July 1, 2011  
Subject: **Portland Marine Terminal**  
Federal Project No: DTMA1G10006/TIGER  
State PIN: 017820.00  
**Amendment No. 2**

Make the following change to the Bid Document:

SHEET NUMBER
C10
13 OF 71

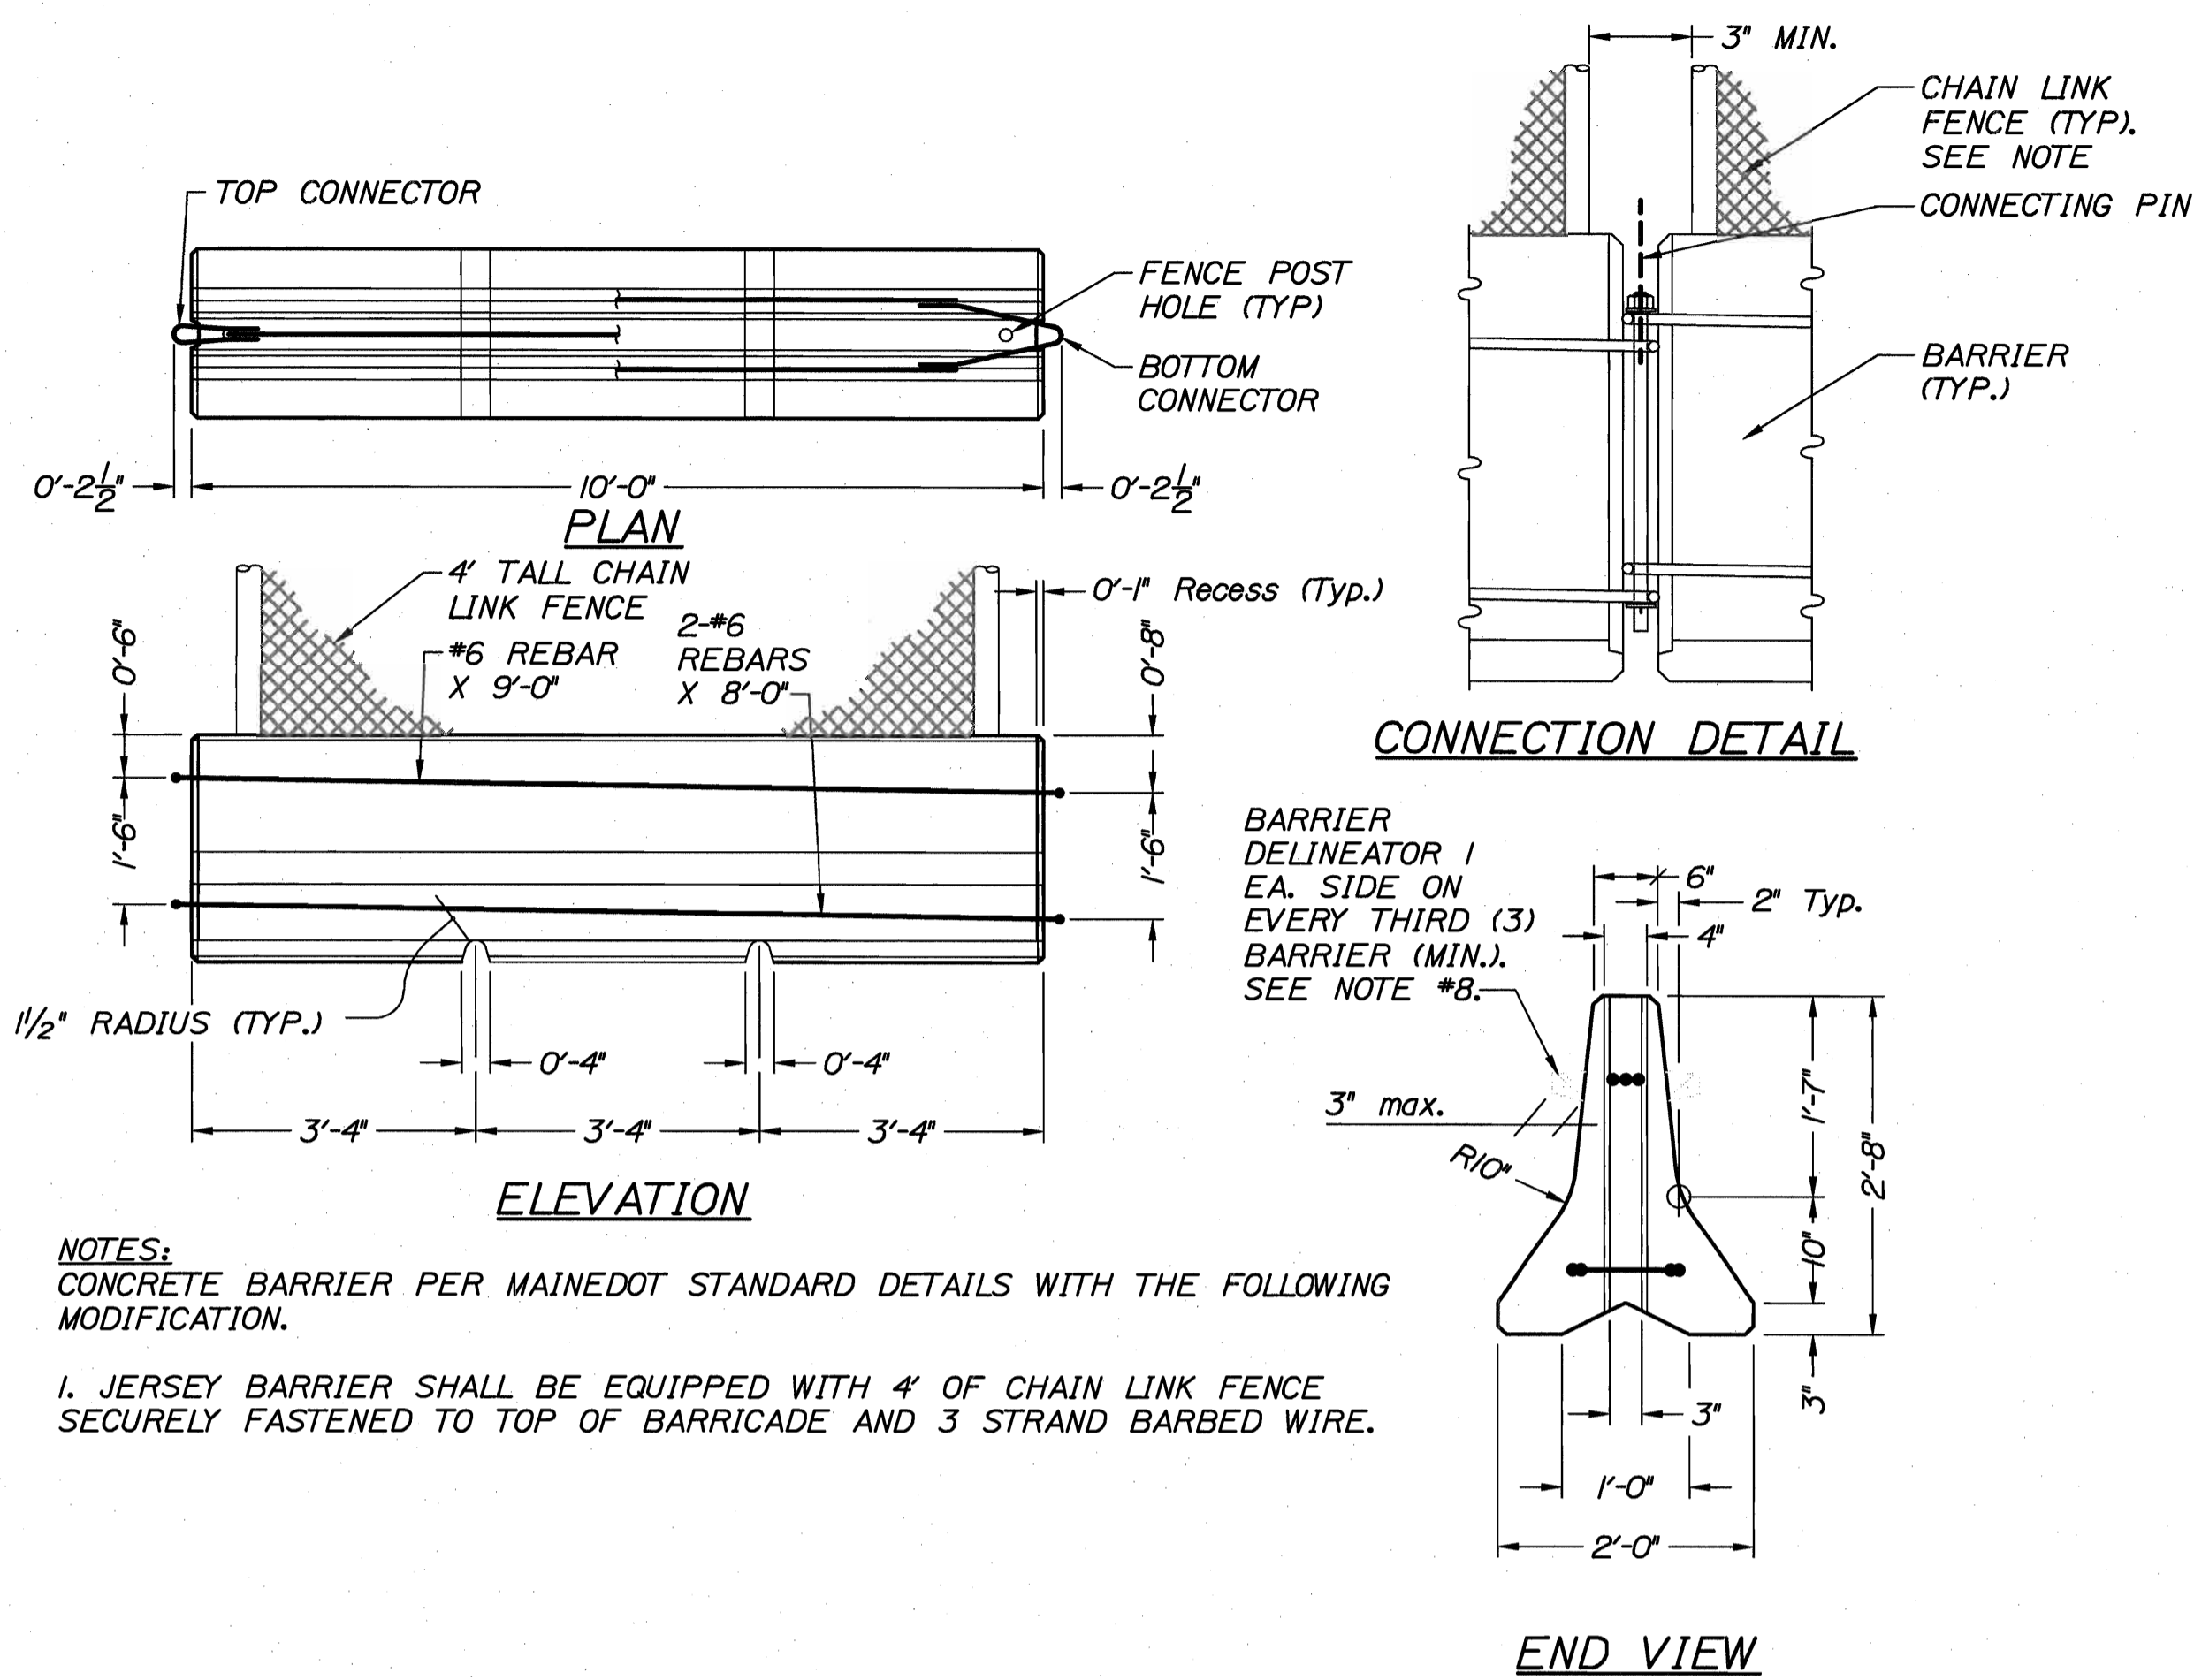
**Question:** Is the 4' fence on top of the Jersey Barrier paid under 607.1601 or 526.301?

**Response:** The 4-ft fence on top of the jersey barrier shall be paid under 607.1601. Please strike the first paragraph of Section 32 31 00, Section 607.07, Basis of Payment.

SHEET NUMBER
C18
 21 OF 71

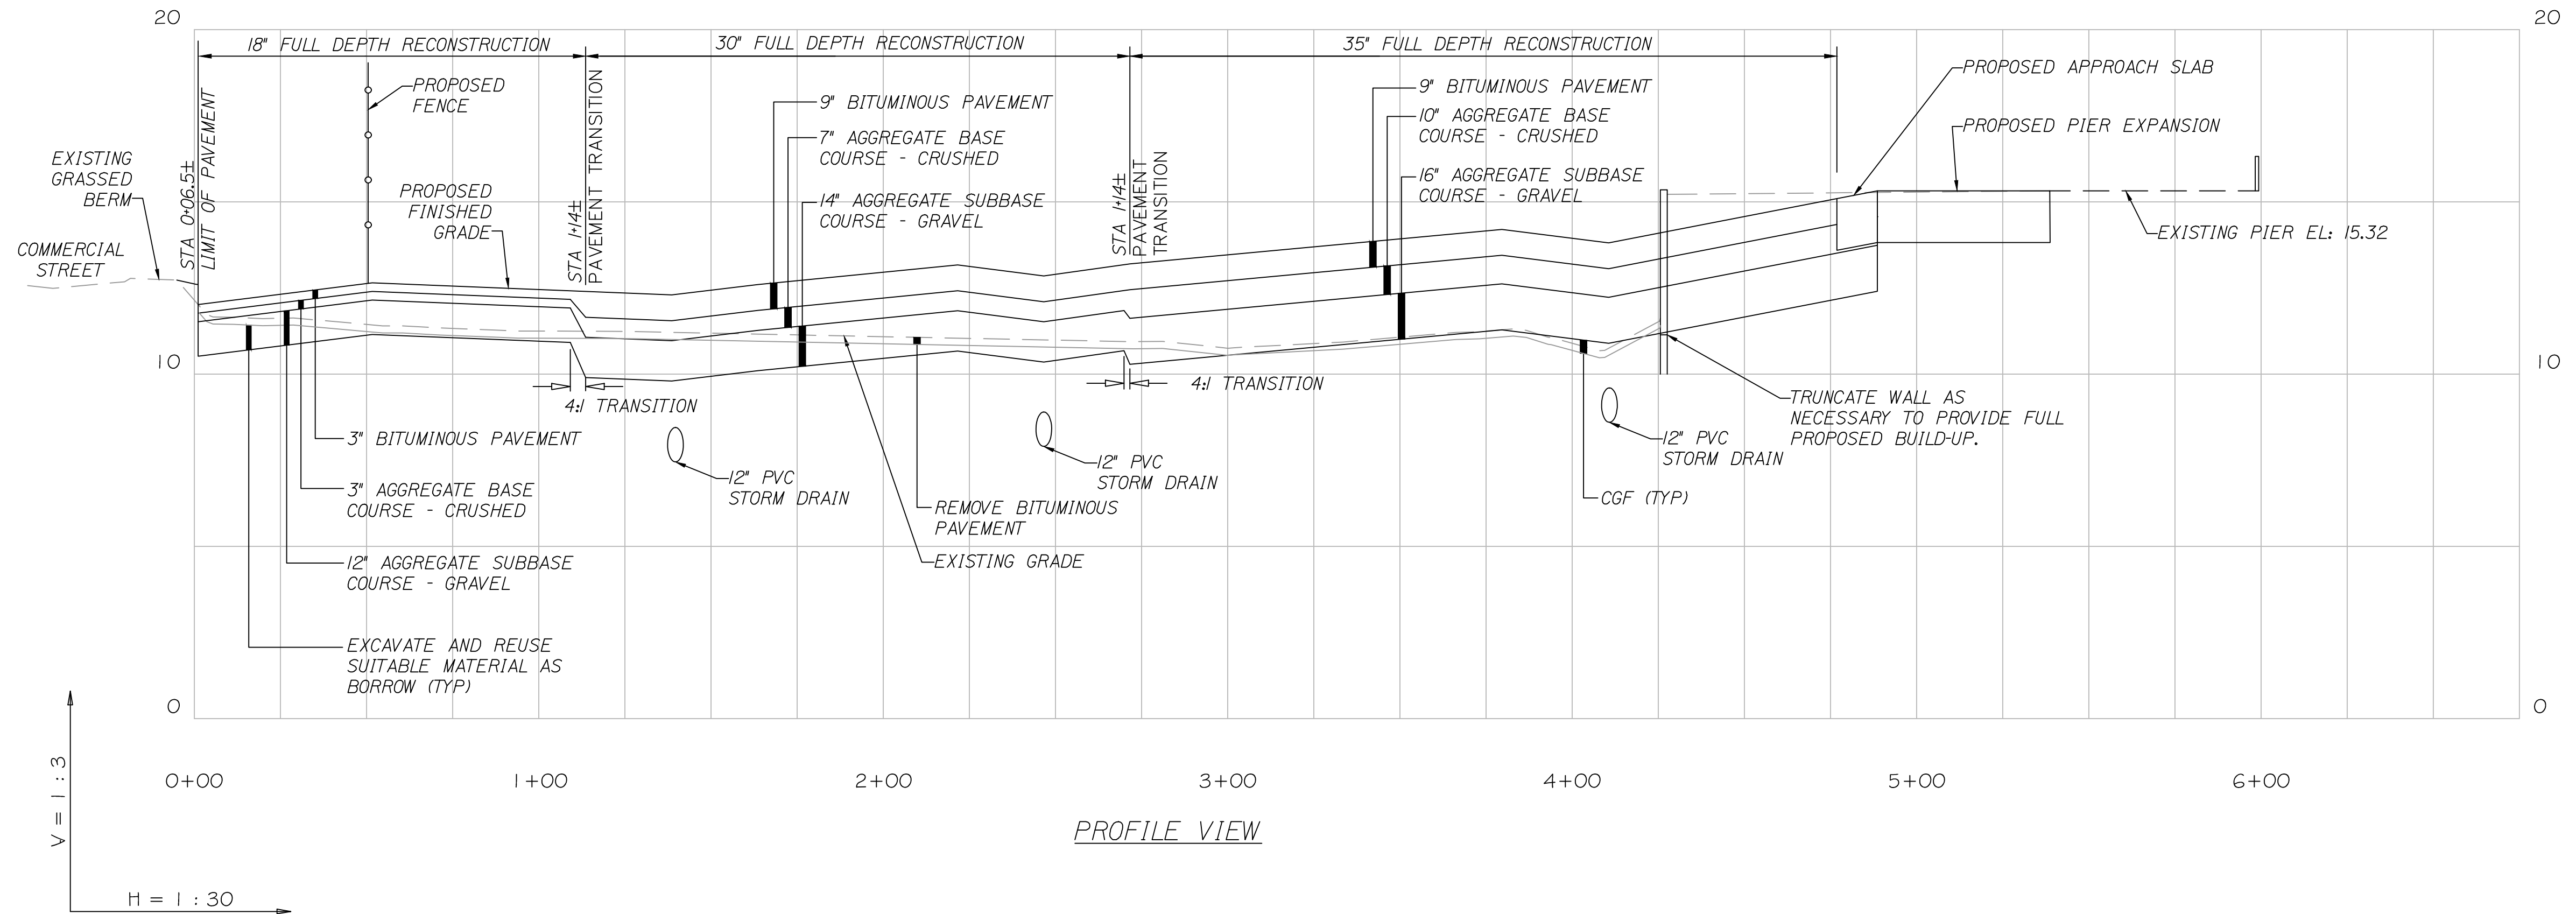
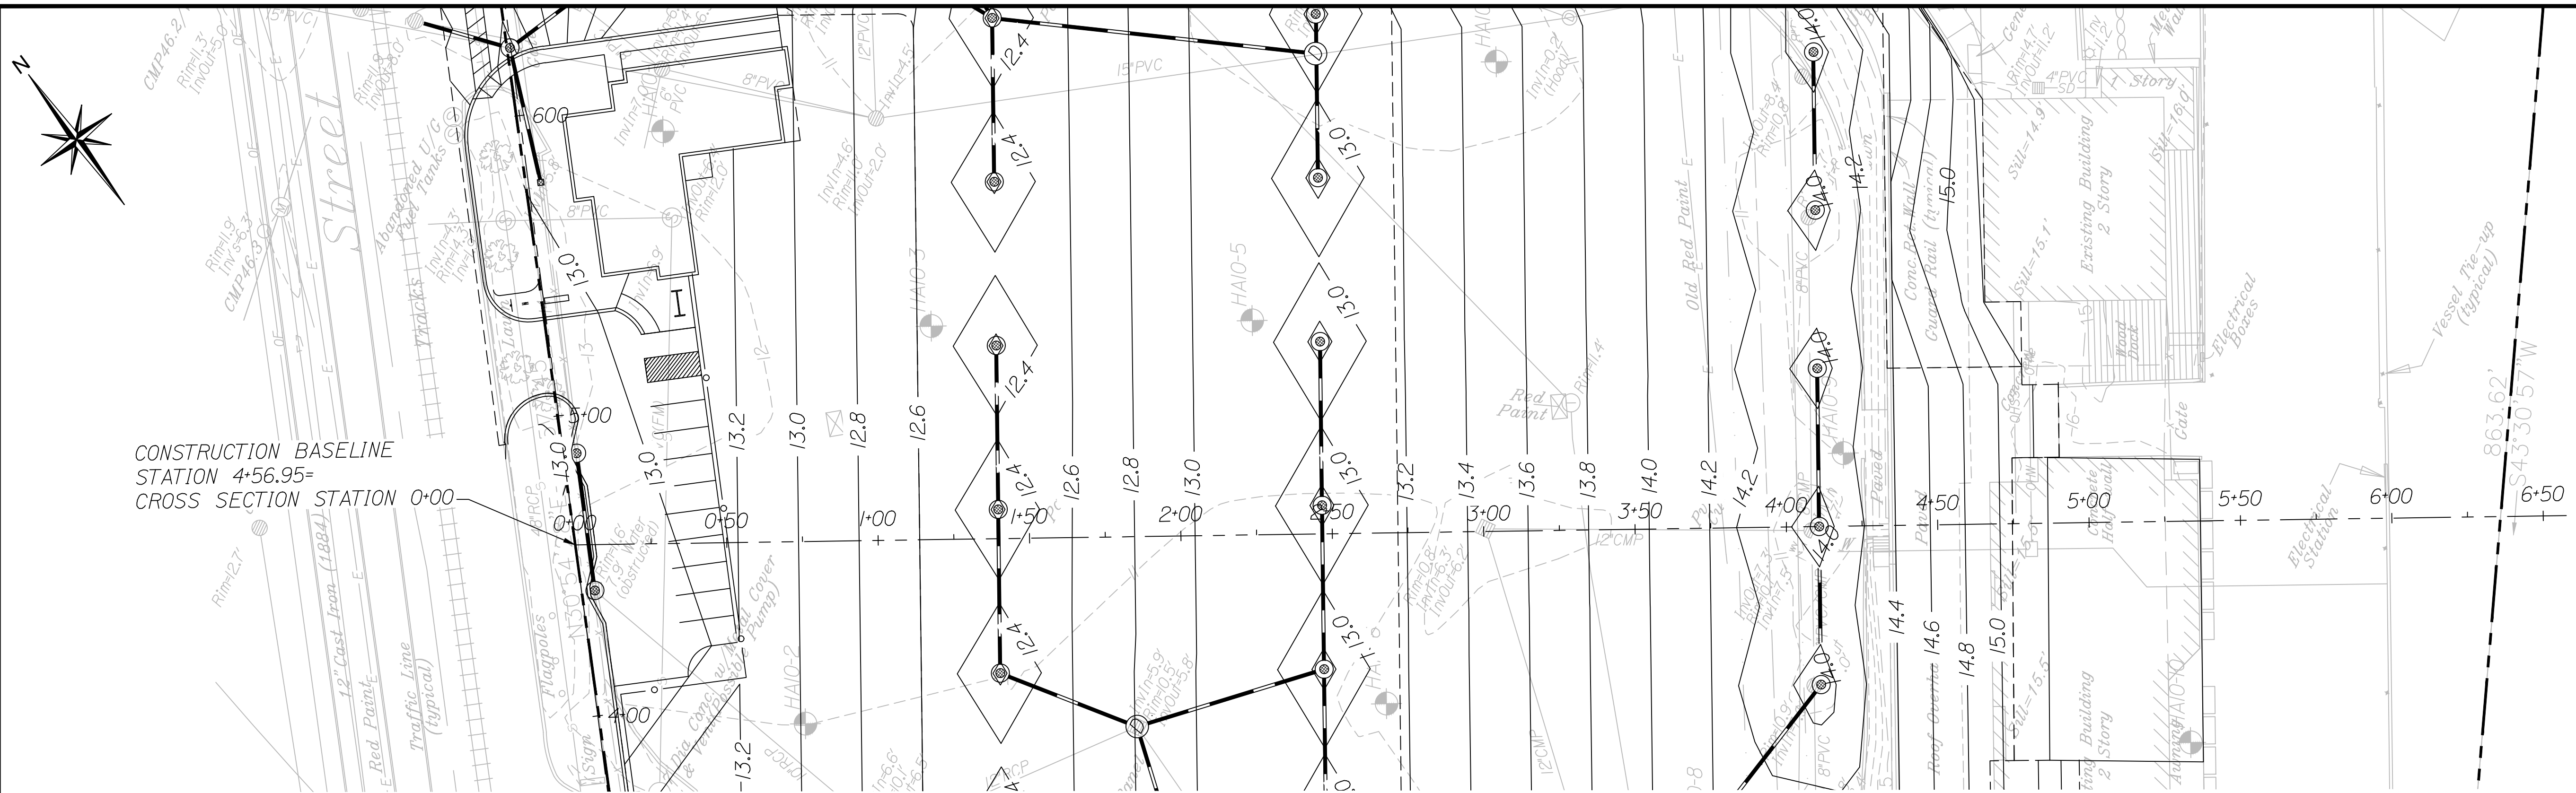
**Question:** Cannot find detail on 502.604 – Structural Concrete, Maintenance Building Slab.

**Response:** On Sheet C18, within the Existing Maintenance Building, please note the area identified by Note 3. The Structural Concrete Maintenance Building Slab is the floor slab at the corner of the building which will be removed and replaced as part of the utility reconnection work. This area is approximately 20 ft by 20 ft with a 6-inch thick reinforced concrete slab.
